**RE: 6<sup>th</sup> and Haines Redevelopment  
Conceptual Grading and Drainage Plan  
Stamp Date: 9/22/17  
Hydrology File: H14D108**

Based upon the information provided in your resubmittal received 9/25/17, the Conceptual Grading and Drainage Plan is approved for action by the DRB on the Site Plan for Building Permit and Site Plan for Subdivision.

SDP-3.1
SHEET 3 OF 10

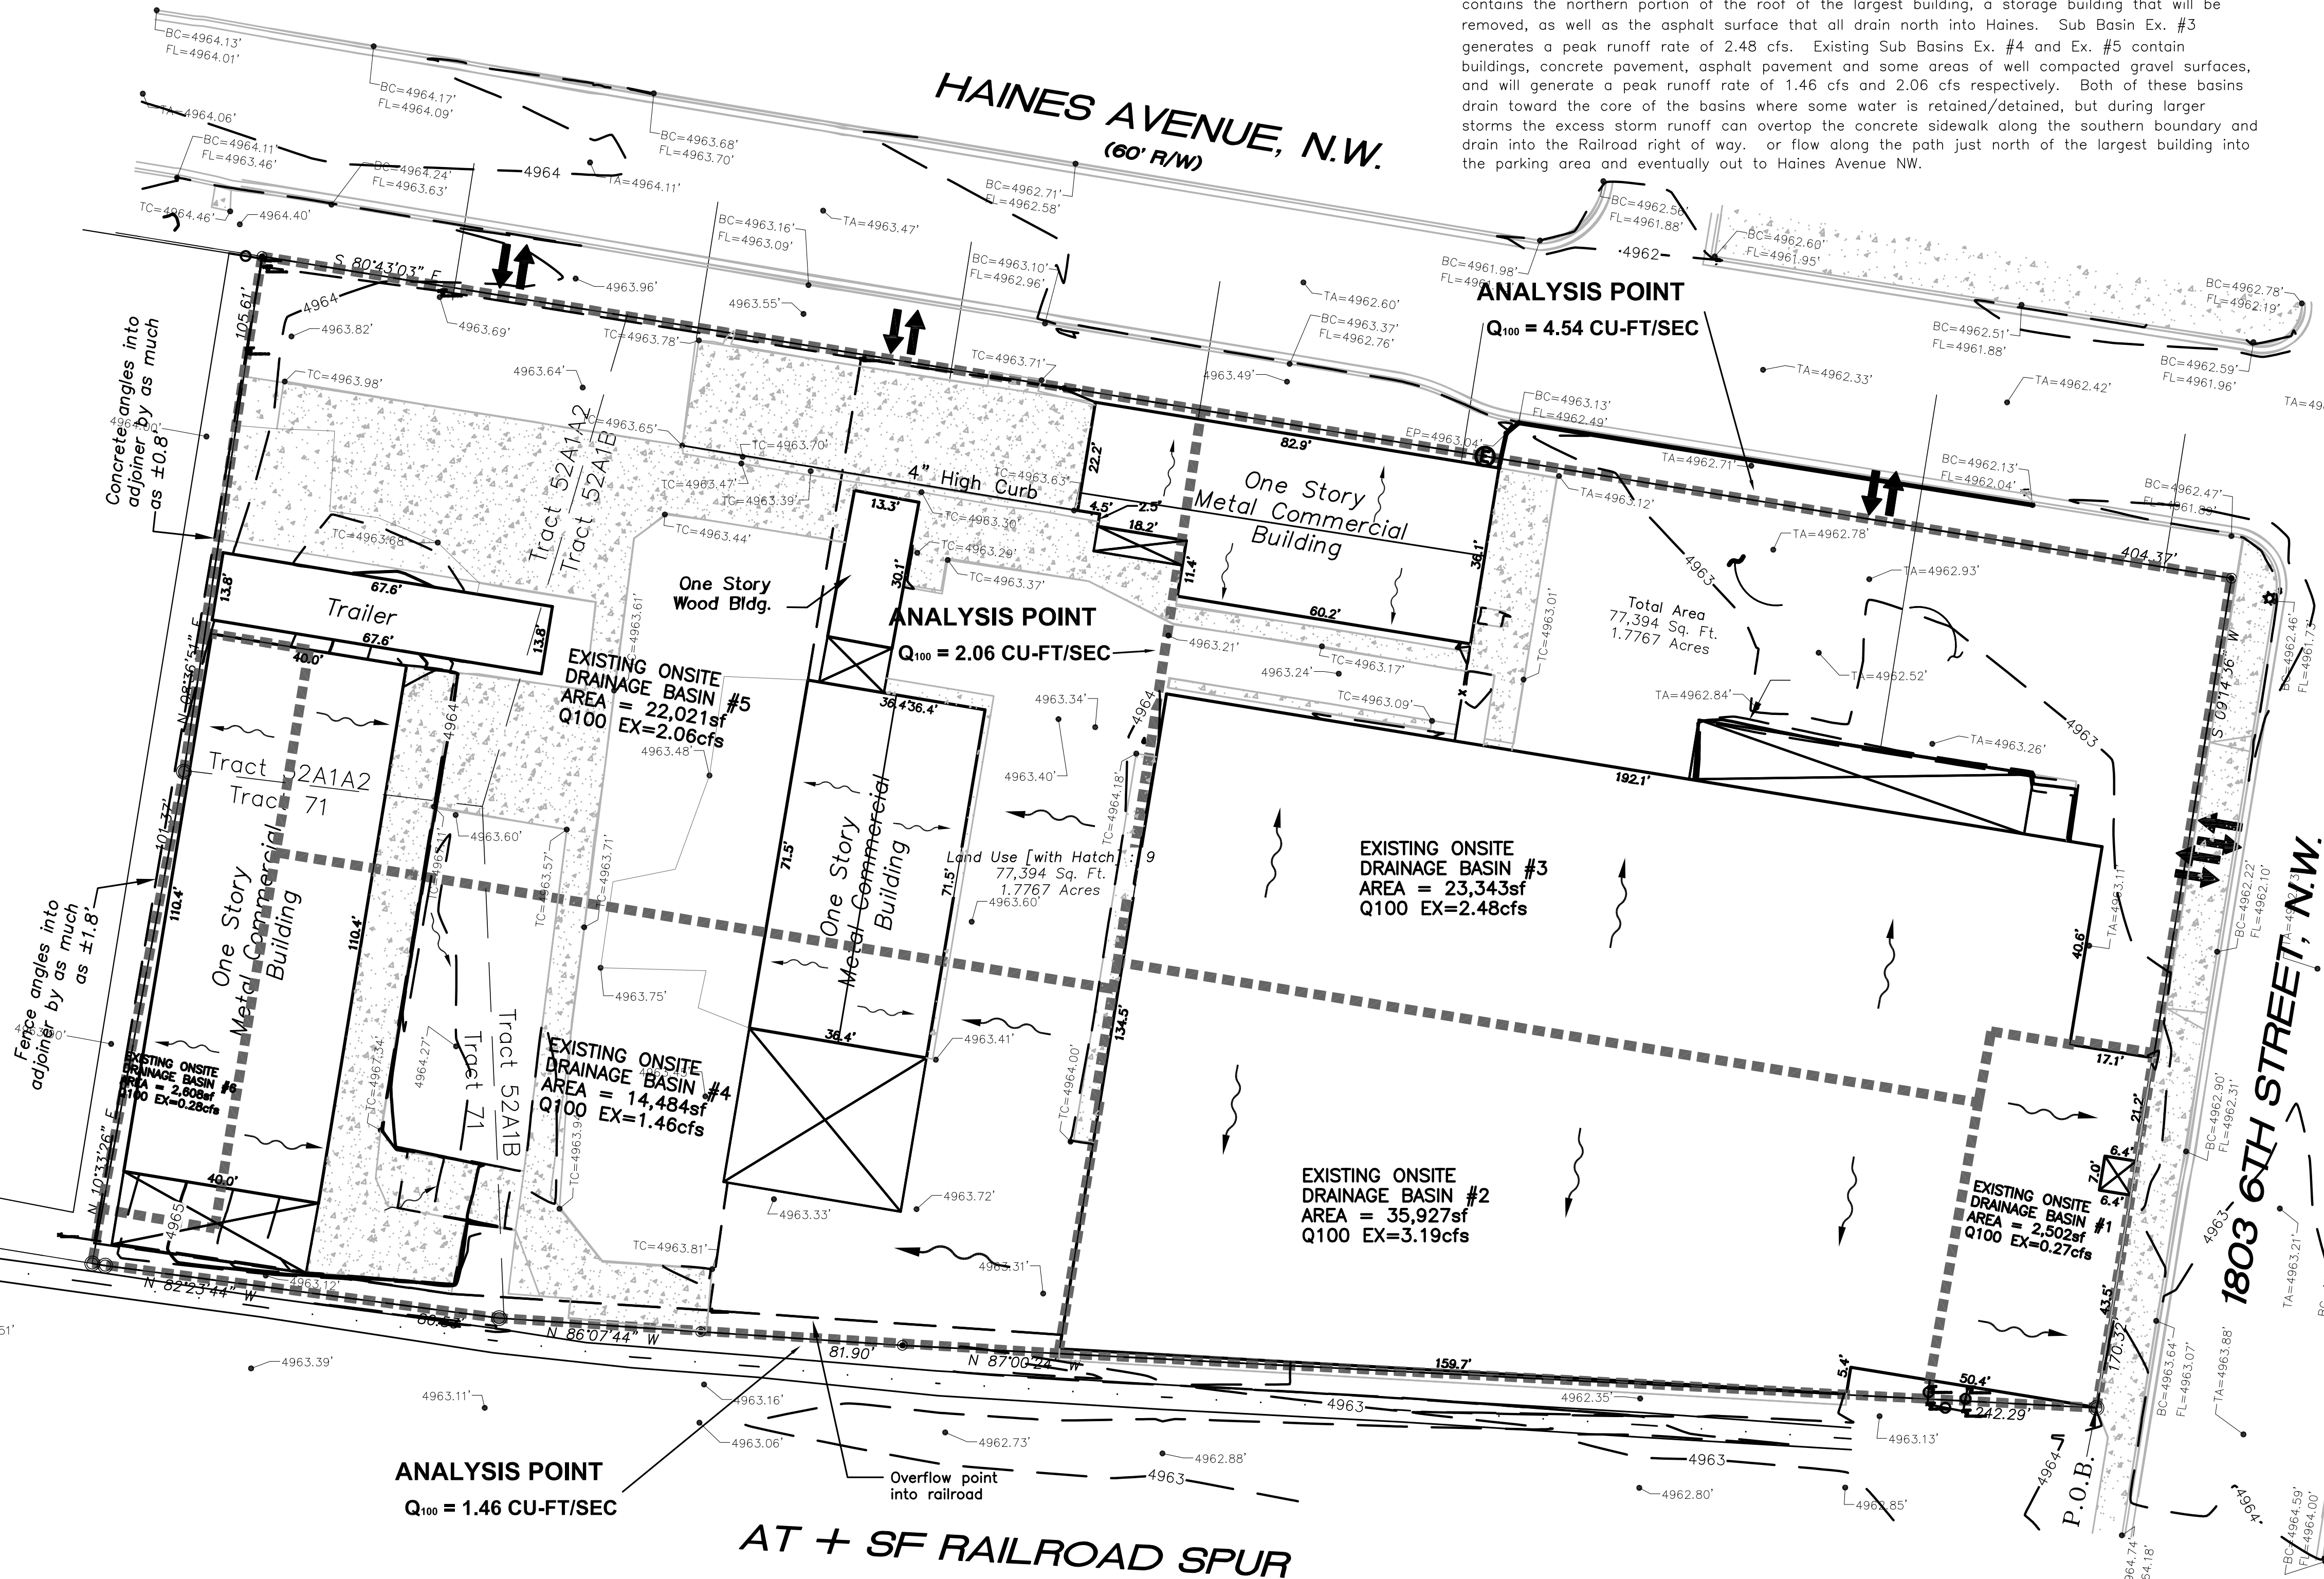
- On Sheets SDP-3.1 & SDP-3.2, please call the sheets "Conceptual Grading and Drainage Plan" and add a note stating "Not for Construction".
- On Sheets SDP-3.2, please call change the Basins to "Proposed" from "Existing".
- On Sheets SDP-3.2, please add the finished floor elevation to the main building.

SDP-3.2

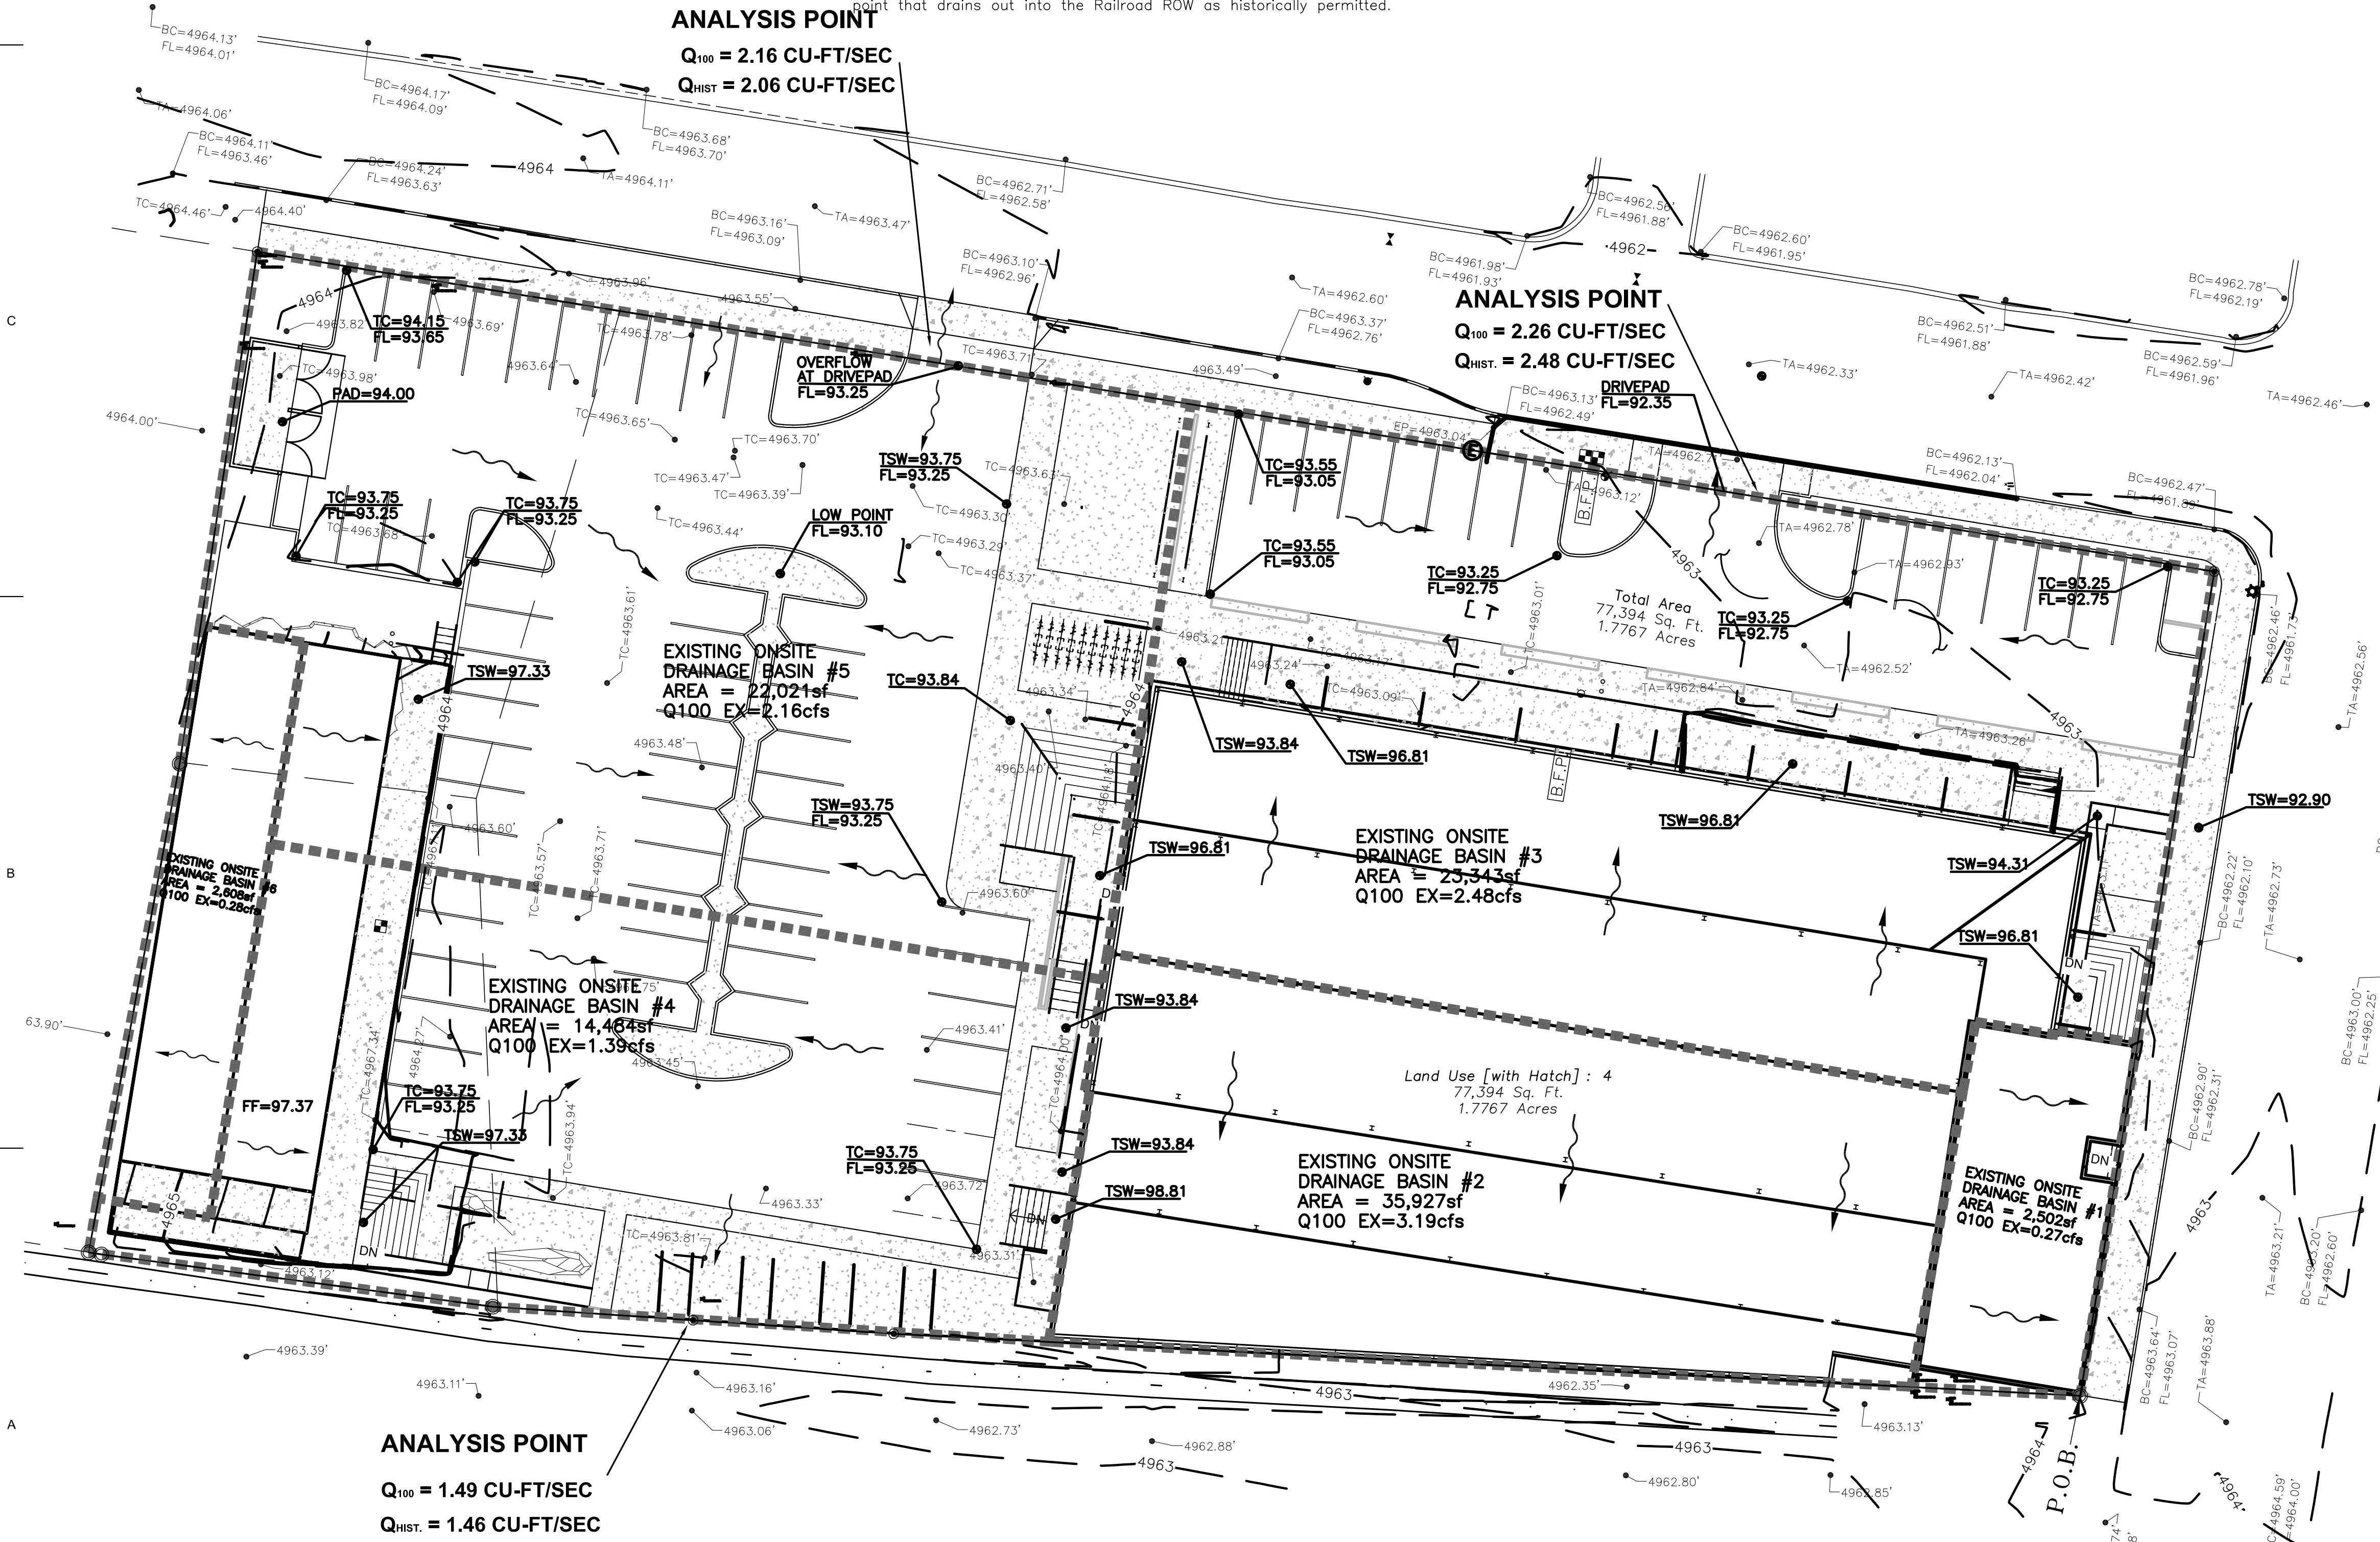
- Please review the Proposed 100 year discharge. I checked Pro 4 and came up with 1.38 cfs instead of your 1.49 cfs.
- Not all basins need a first flush pond. Only Basin Pro 5 needs one since the impervious area increased.
- Please add a curb cut or cuts to allow runoff to inter the first flush pond within the depressed landscape areas.
- Please show the weir calculations for the proposed curb cut or cuts.
